DECISION DELEGATED TO HEAD OF PLANNING**DECISION DELEGATED TO HEAD OF PLANNING**

Application No: H06-0868-21 **Applicant:** Home Improvements

Proposal: Erection of pair of 2 bed semi-detached dwellings

Location: Adj. Sea Breeze Marsh Road Gedney Drove End

Himp/Ged/2021/Gndpln/1

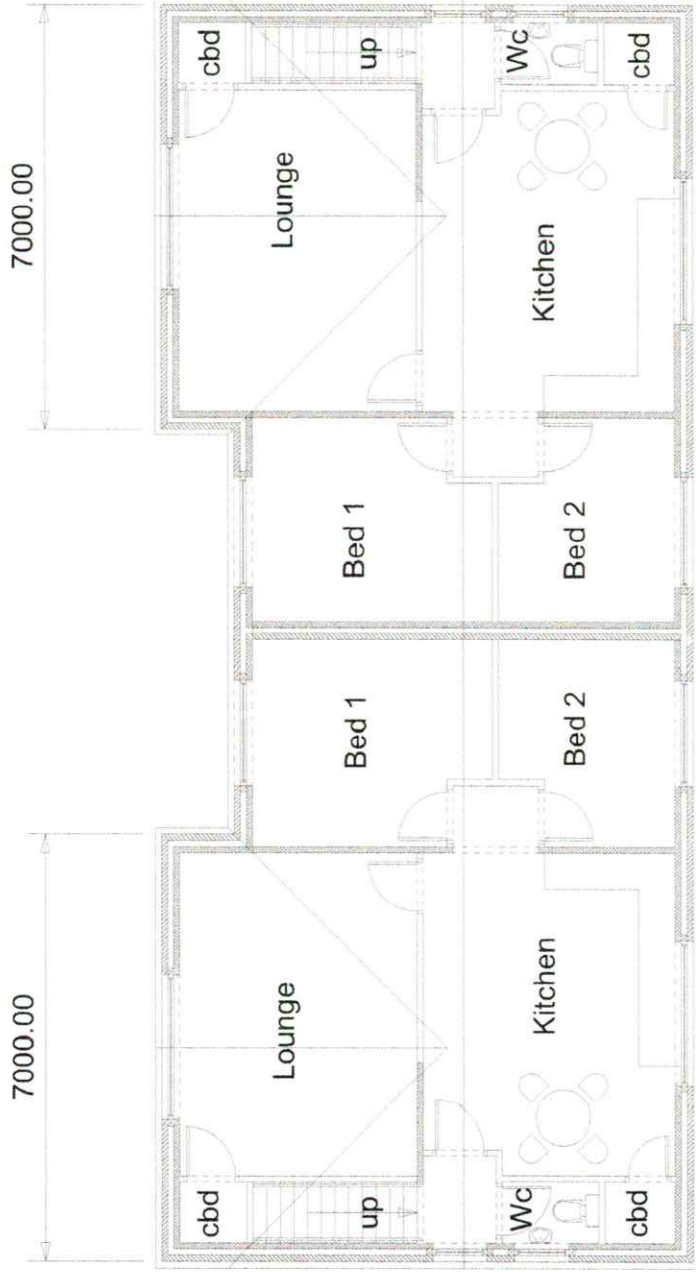
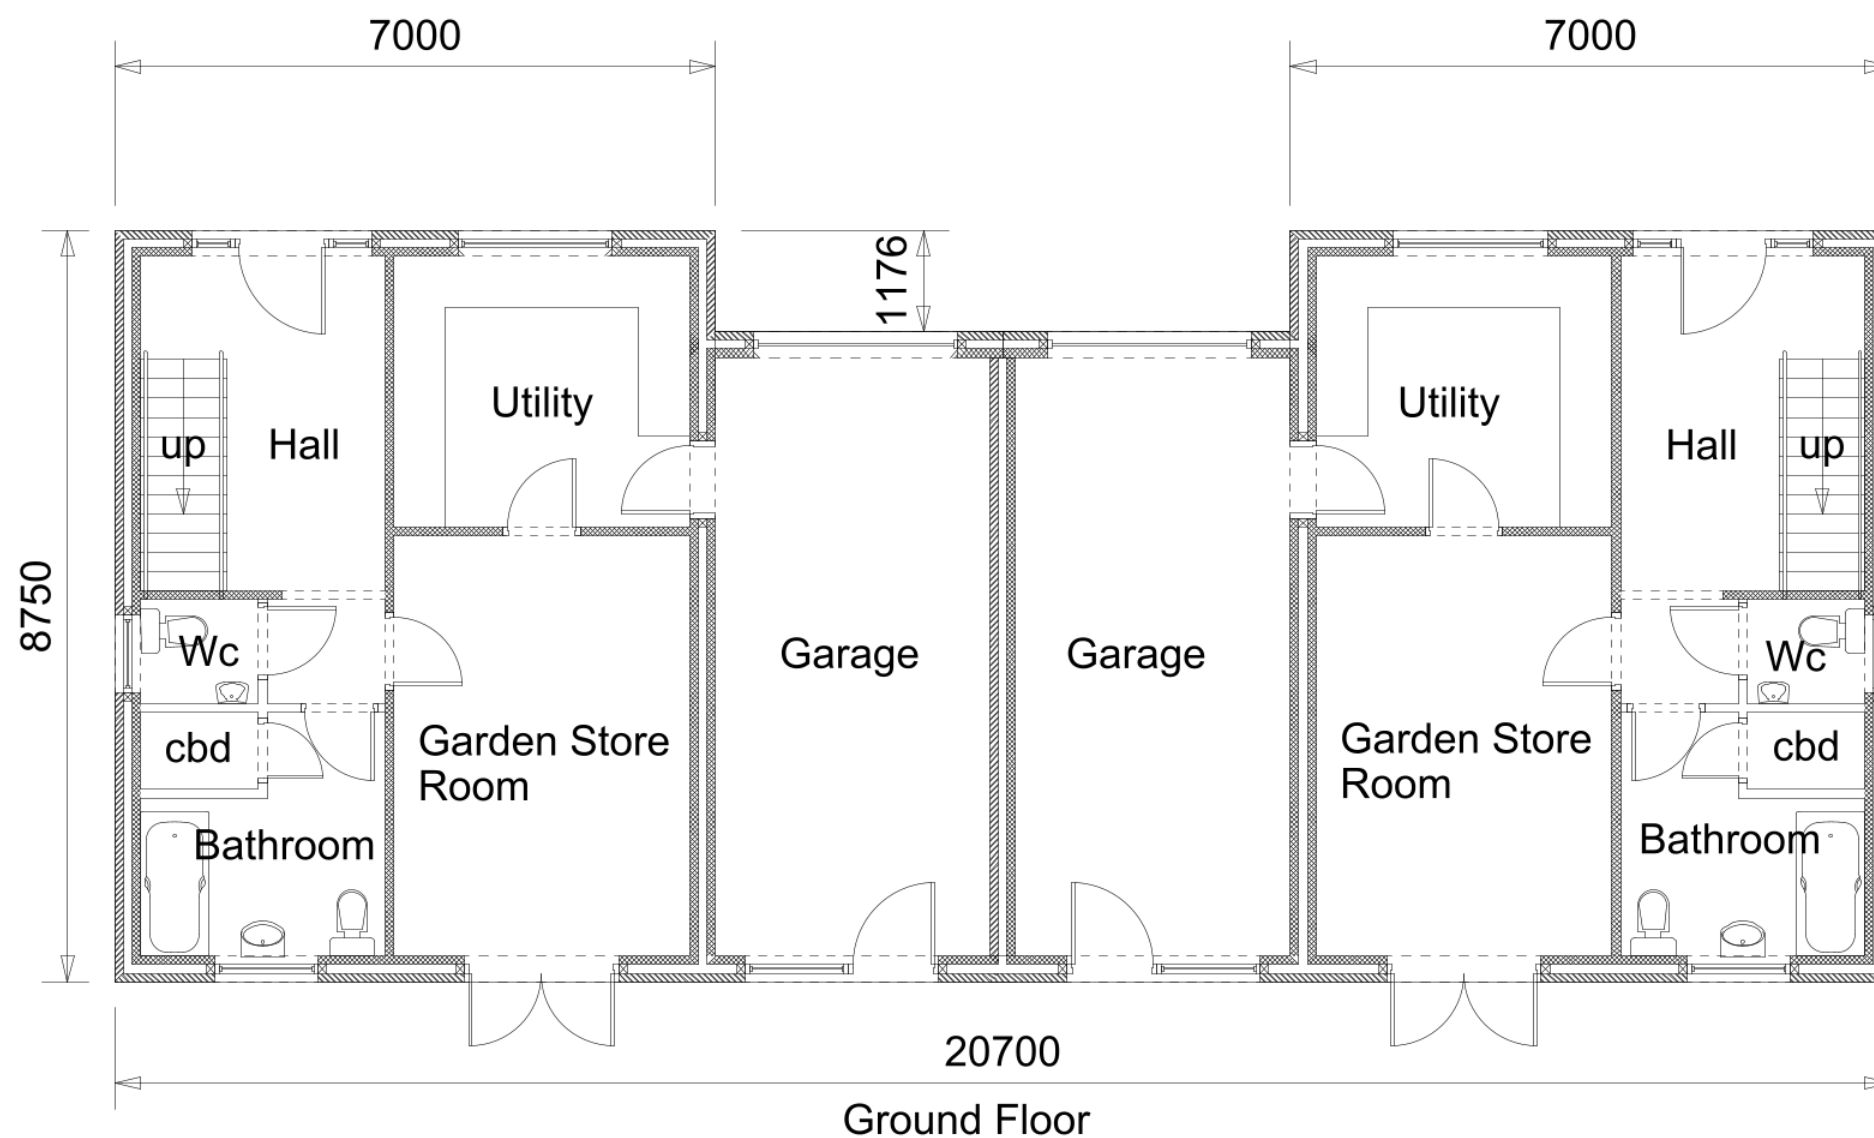
The local planning authority should determine whether they consider the proposed "garden rooms" shown in the ground floor drawing (ref: Himp/Ged/2021/Gndpln1) to be classed as non-habitable. It is unlikely that mitigation measures would prevent flood water from entering the building at ground floor level. Therefore, proposals must have a minimum of 2 storeys with no ground floor habitable accommodation. The first floor living accommodation must be above the highest predicted flood depth.

At the time of the outline permission the Environment Agency requested mitigation measures and for no habitable rooms to be located on the ground floor. The initial ground floor plan submitted included garden rooms and the Environment Agency has advised that the local planning authority should determine whether they consider the proposed garden rooms as non-habitable. It is unlikely that mitigation measures would prevent flood water from entering the building at ground floor level. Therefore, proposals must have a minimum of 2 storeys with no ground floor habitable accommodation. The first floor living accommodation must be above the highest predicted flood depth. The concerns were noted, and the applicant was advised to remove the garden rooms from the ground floor. The revised plans omit the garden rooms initially proposed and now proposed only non-habitable rooms on the ground floor.

The plans have been amended as the ground floor plan initially showed a garden room which was not considered acceptable due to the site being within a flood risk zone.

Himp/Ged/2021/Firtflrpln/1

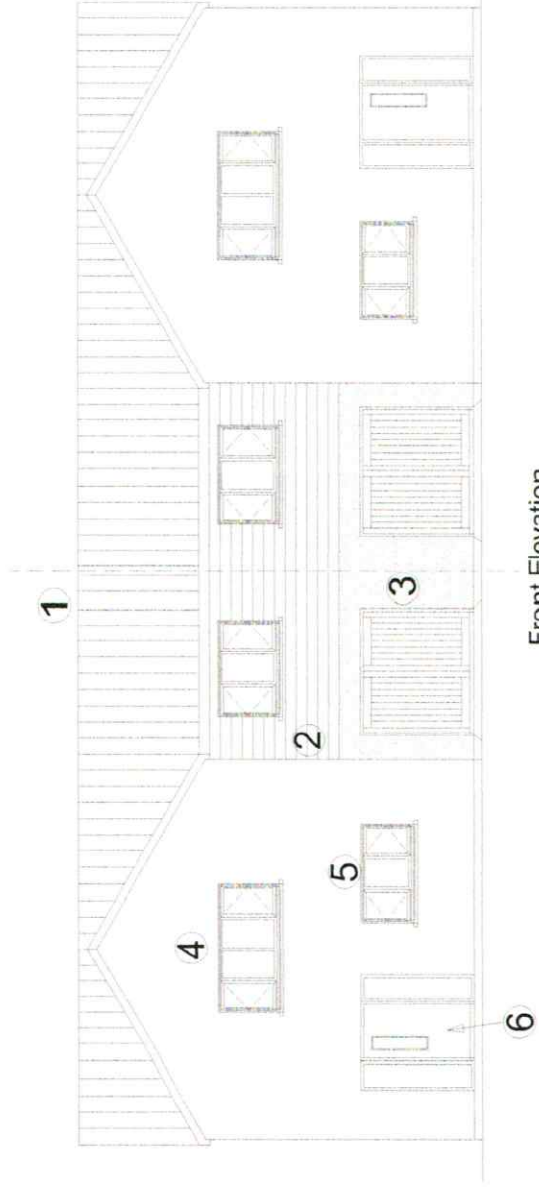
The adjacent neighbour has raised concerns that proposed side facing windows would result in overlooking and loss of privacy. The concerns are noted, however, the proposal does not propose any side facing primary room windows. The first floor side facing window would serve a bathroom therefore it would be obscure glazed. As such it would not result in any overlooking or loss of privacy. The scheme is also not considered to result in any overbearing impact given the dwelling closest to this neighbour would be sited approximately 4.5 metres from the shared boundary with this neighbour and 7 from its nearest elevation. In addition, given the orientation of the property and the fact this neighbour does not have any windows in its side elevation facing the application site no unacceptable overshadowing would result.

With regards to the neighbour to the north-west, the proposed dwellings would be located approximately 4.5 metres from the shared boundary with this neighbour and at least 12.2 metres from this neighbour's nearest elevation. This separation distance is considered sufficient given this neighbour also does not have any primary windows facing the application site. Only one first floor window is proposed directly facing this neighbour, however, this would serve a w/c and therefore condition has been appended to ensure this window is obscure glazed. As such there are no overlooking or loss of privacy concerns.
